Harnett County

Permit Number: BCOM2603-0006

Description: **Hispanic Snack Convention Bar**

Site Address: **161 S MCKINLEY ST**

SHEET 1 OF 2

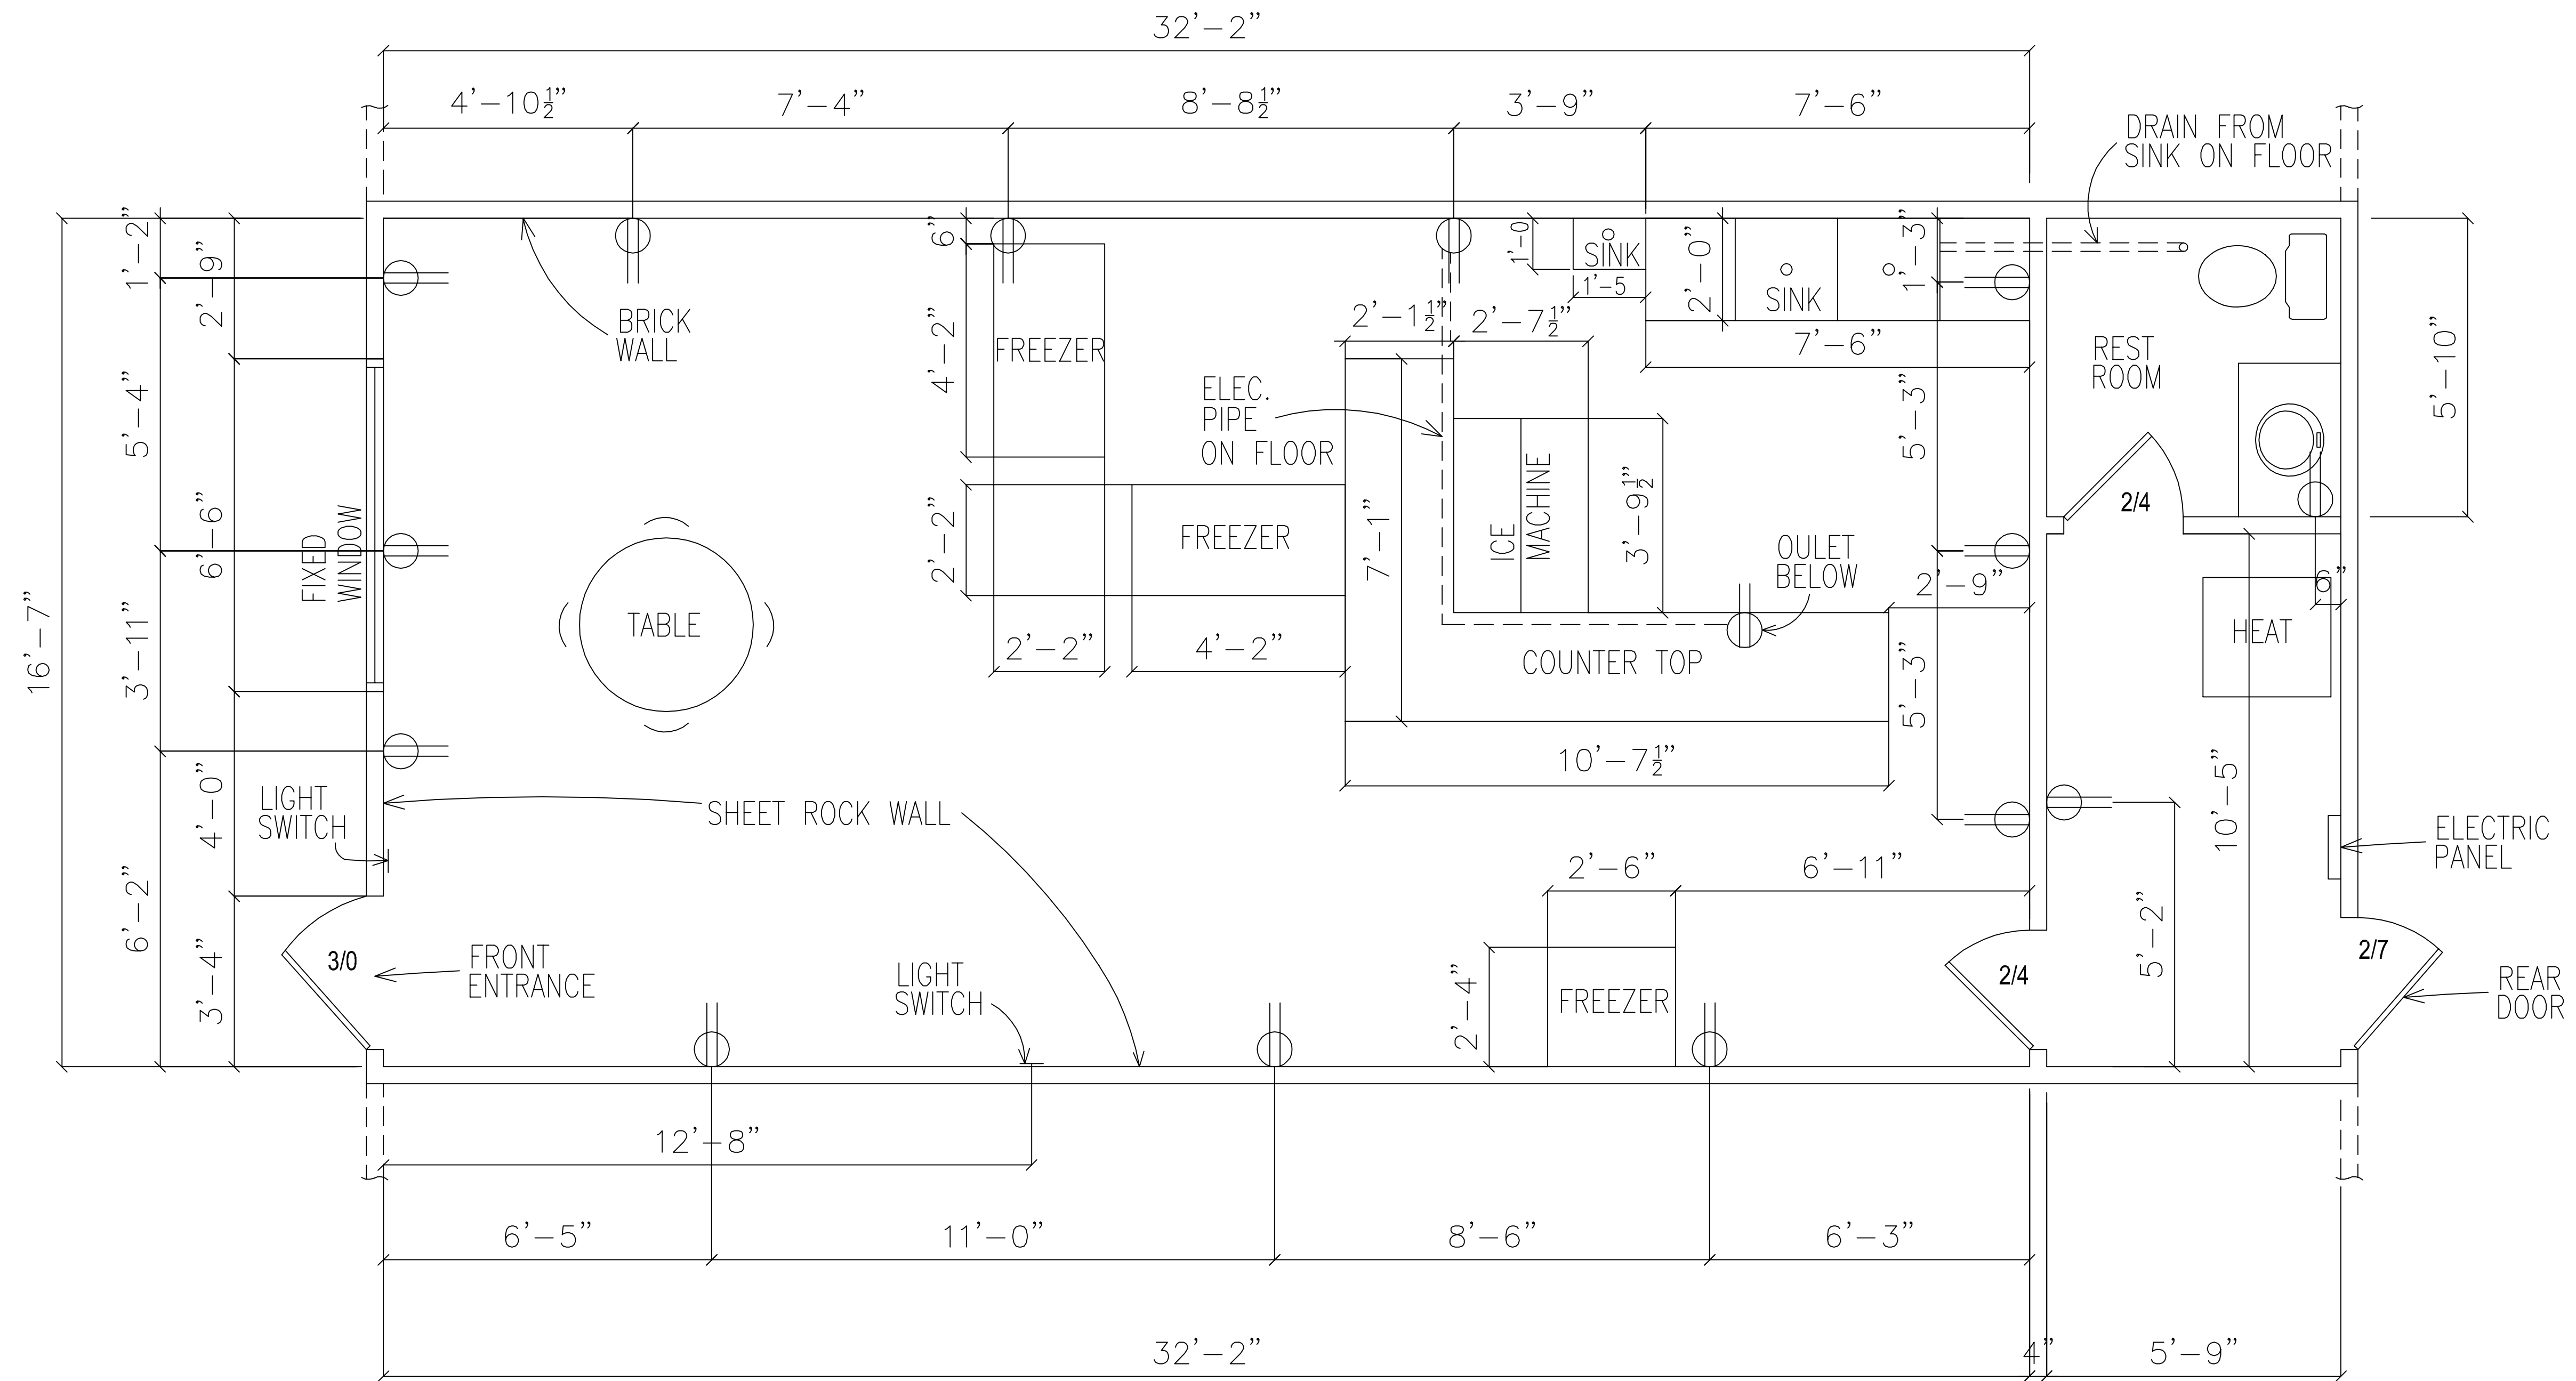
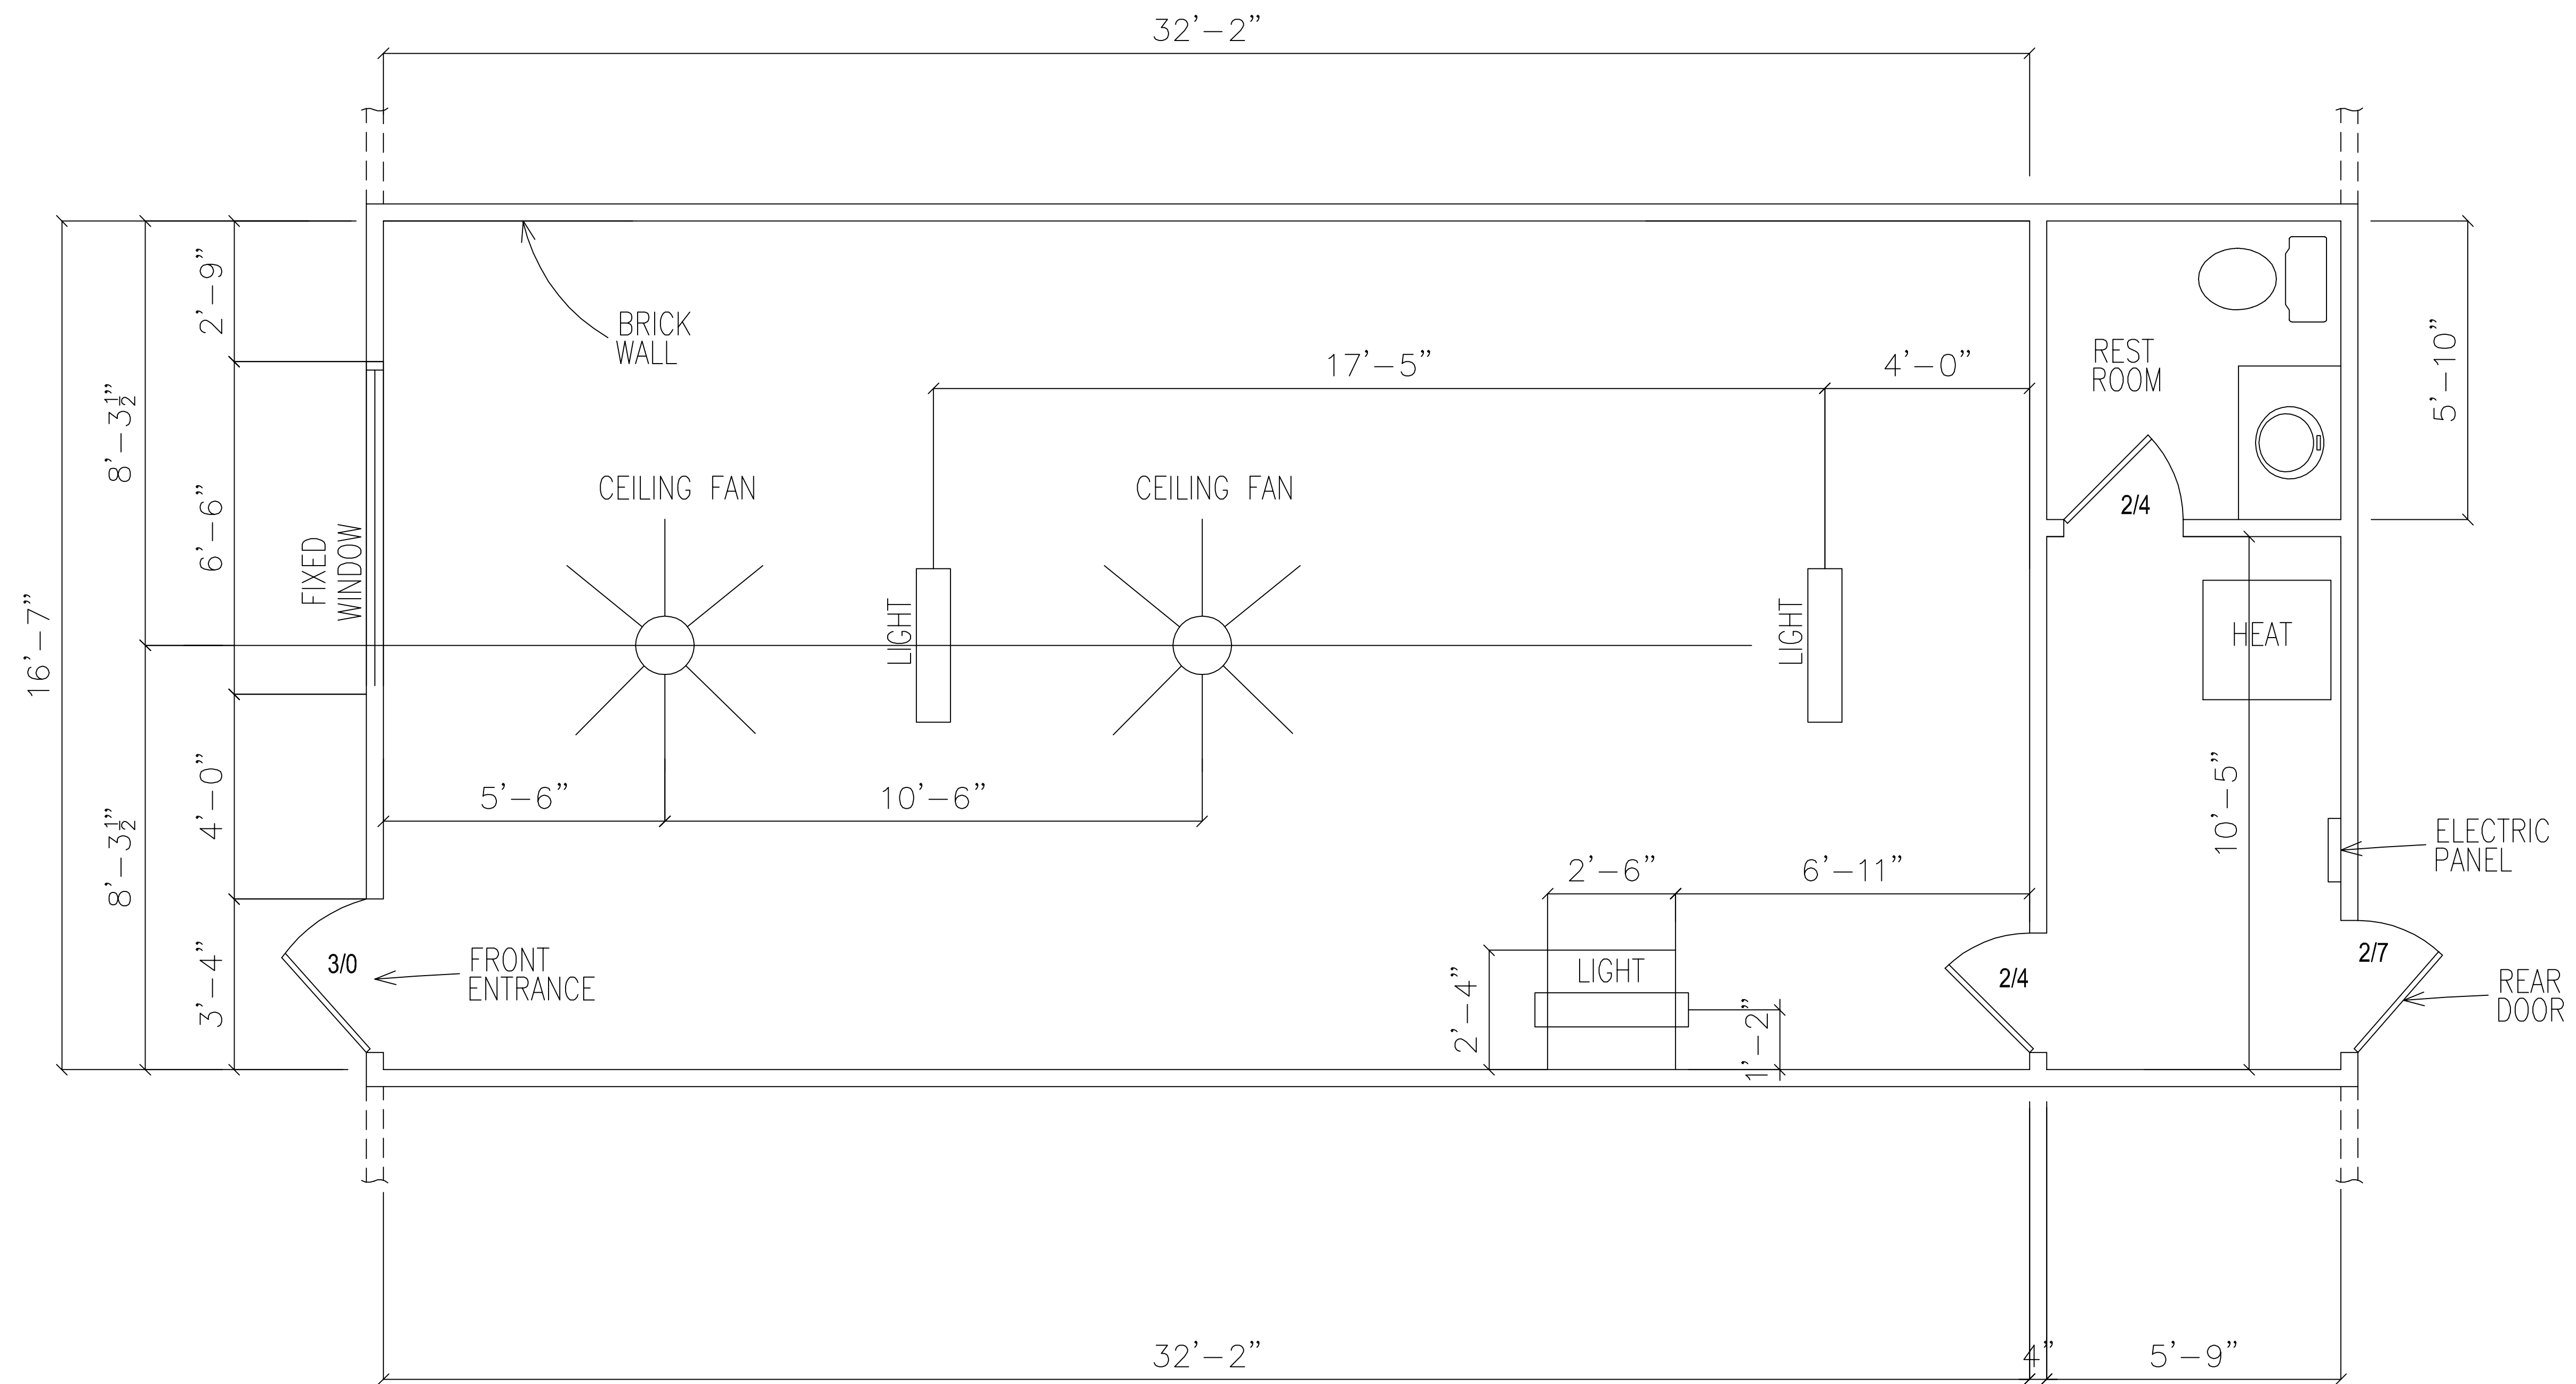
SENT DATE	RETURNED DATE	DUE DATE	TYPE	CONTACT	STATUS	REMARKS
Review Group: 1ST PLAN REVIEW						
3/25/2026	4/1/2026	4/9/2026	FIRE MARSHAL	Fire Bucket	DISAPPROVED	See Notes
Notes:						
- Life safety plan, fire extinguishers, emergency and exit lighting.						
- Cooking hood plans if any cooking or frying will be done.						
3/25/2026		4/9/2026	PUBLIC UTILITY	Public Works		
Notes:						
3/25/2026			HEALTH AND SANITATION	EH Bucket		
Notes:						
Review Group: AUTO						
3/25/2026	3/25/2026		COMMERCIAL INTAKE	CP Bucket	DISAPPROVED	
Notes:						
3/25/2026	4/1/2026	4/9/2026	COMMERCIAL BUILDING REVIEW	Brad Sutton	DISAPPROVED	
Notes:						
Need a scaled plan						
Need food details. Cooking? Prepackaged? If cooking, provide hood and cooking equipment details						
4/1/2026			COMMERCIAL BUILDING REVIEW	Building Bucket		
Notes:
